HANSON CONSTRUCTION MATERIALS
SANCROX QUARRY EXPANSION

INDEPENDENT PEER REVIEW OF SANCROX QUARRY EXPANSION GROUNDWATER MODEL

GW-HANSON-20-02-REP-001

Date : 07 SEPTEMBER 2020

Figure 2-1 Groundwater monitoring bores

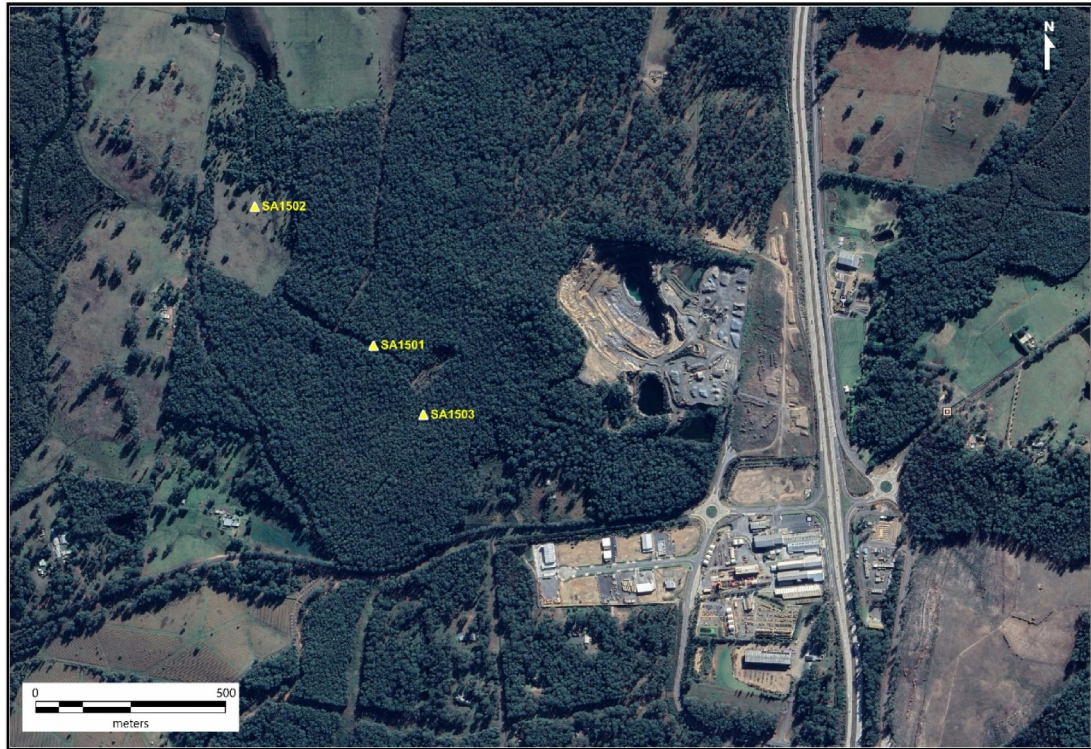
These bores are located in a near straight line which is not ideal for inferring groundwater flow directions spatially within the study area. Historical water levels that were collected from these bores were neither provided nor analysed to understand the hydrological stresses. It is also noted that no hydrogeological information from the surrounding groundwater bores, GW060512, GW060513, GW300120, GW301263, GW302376, GW303436, GW303749 and GW306269, has been included in the groundwater model development.
